**Application for a non-material amendment following a grant of planning permission,
Town and Country Planning Act 1990**

**Non material amendment to previous permission 2020/91746 for erection of extra
care development providing 80 apartments with associated communal facilities and
landscaped gardens**

Land off, Kenmore Drive, Cleckheaton, BD19 3EJ

Application Number: 2024/92159

PROPOSED ROOF PLAN

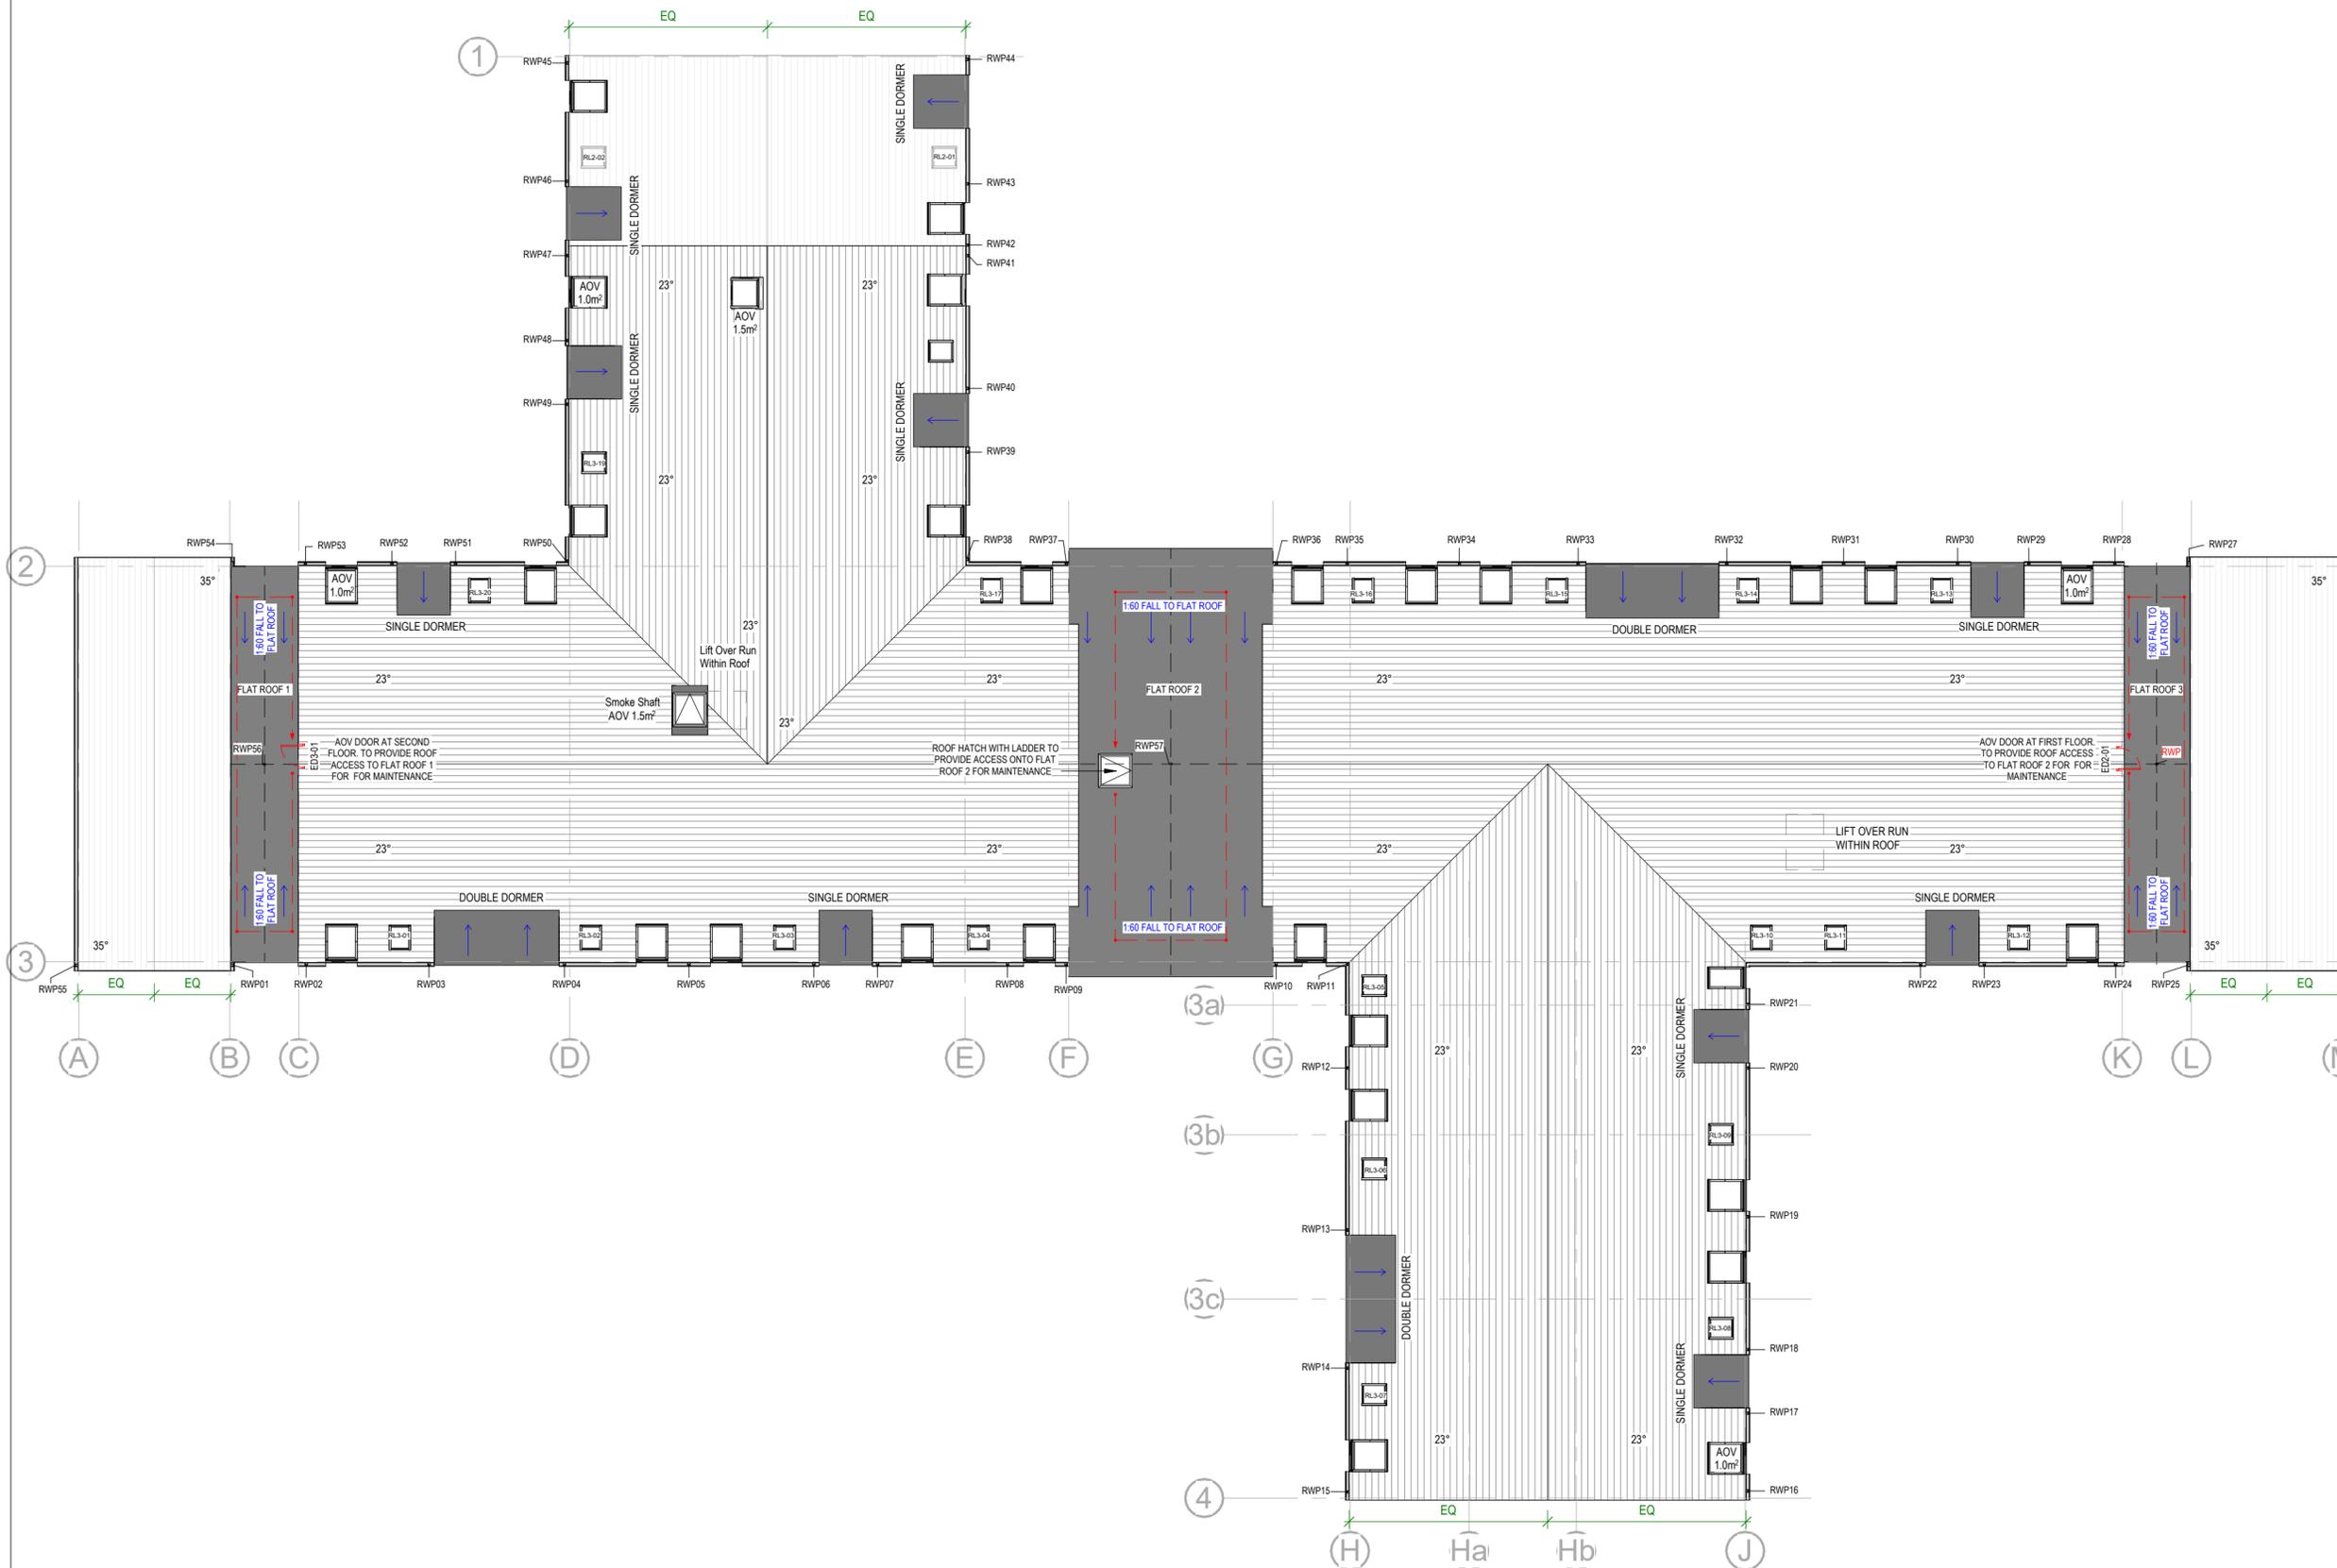
- Omission of internal atrium including glazing on the roof slope (west and east elevation)
- Increase in height of flat roofs to allow for larger service voids for accommodation of M&E equipment. Flat roofs 1&3 have raised by approximately 500mm and the middle flat roof 2 has raised by approximately 300mm

- Automatic opening vent details added (west elevation) and projection through roof (north elevation, west elevation)
- Change of dormers to combination rooflight (south elevation, north elevation)

- Combination rooflight revised to single pane (all elevations)
- Recesses for rain water pipe omitted (all elevations)
- Ground floor buggy store single door change to double door (south elevation)

I confirm that the alterations are acceptable and may be considered as a non-material amendment to the approved drawings.
